Your Ref: OWPC24056
Our Ref: LU/242/19/HH 30-07-2019
Please ask for:
Zac Denton

Single storey front and rear extension and porch to front. Addition of 1 No. balcony to first floor and change of external finishes.

5 Reef Close Littlehampton

Drawing:
Ground floor

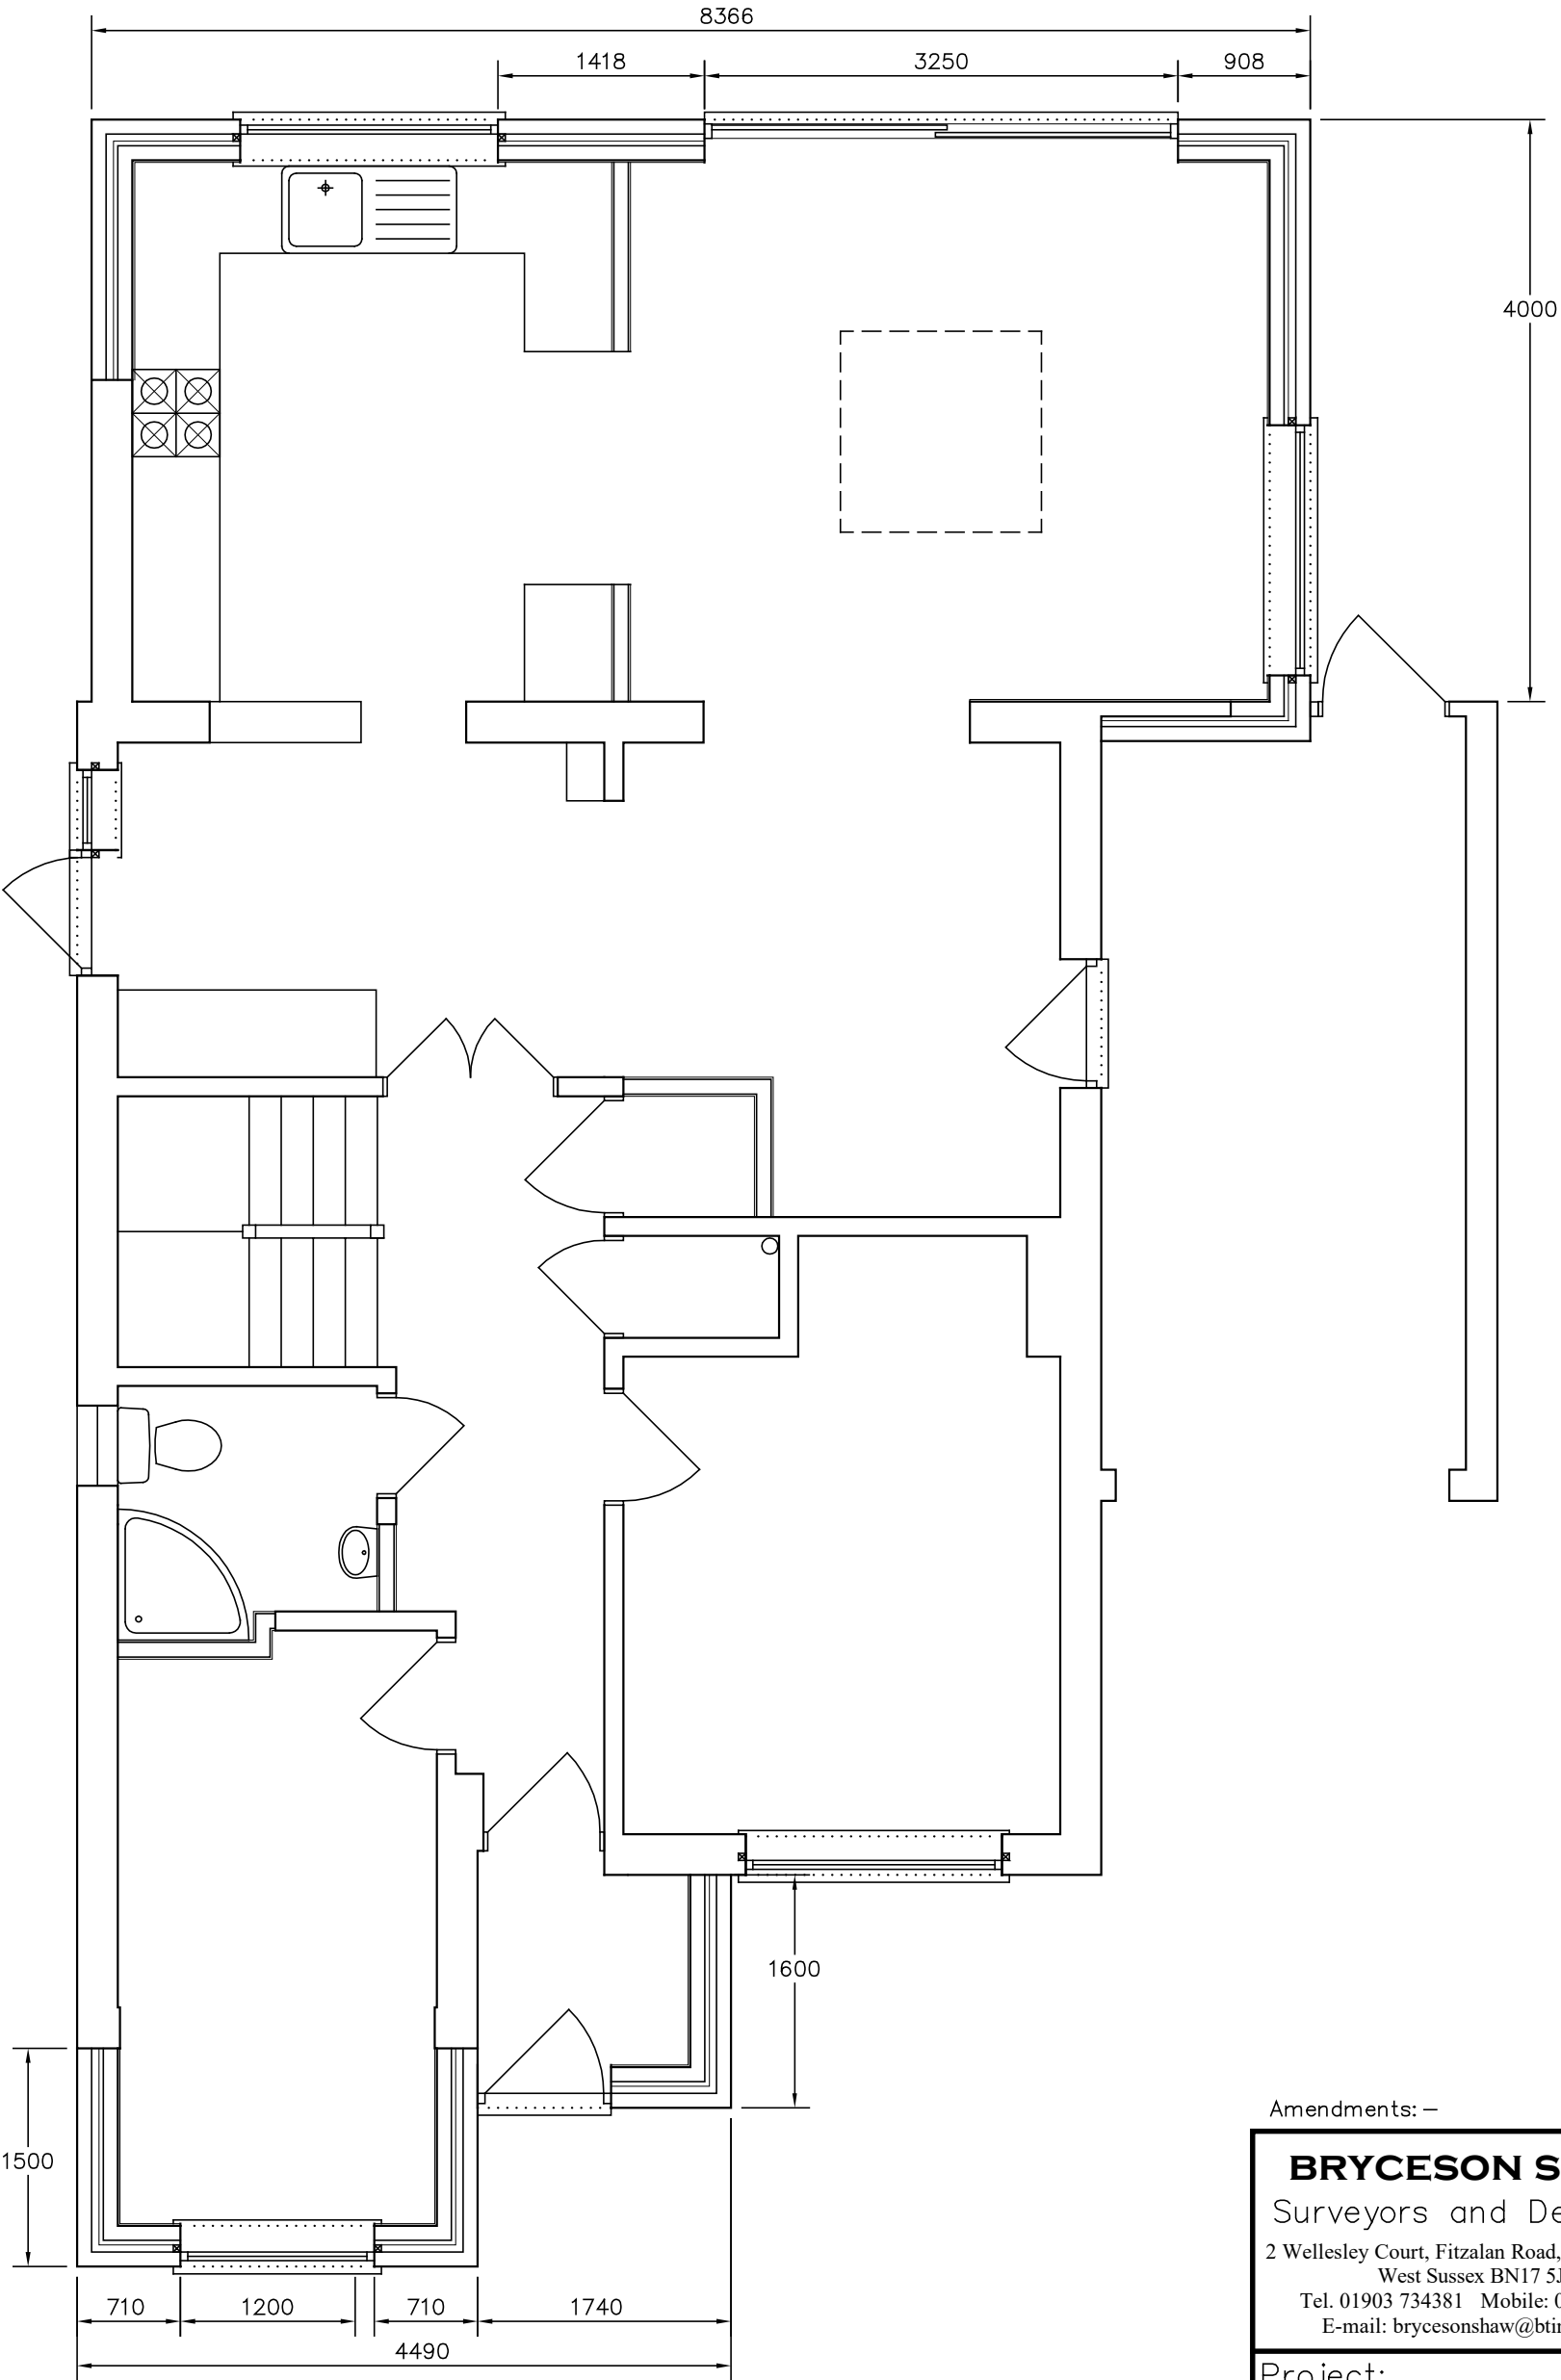
The proposed rear extension is twice the size of existing one and the proposed new balcony extending 4 meters out will overlook my garden and take away all privacy. Also, the front extension is described as a 'Porch' when in fact from the plans it looks like a bedroom extension and more detail would be appreciated.
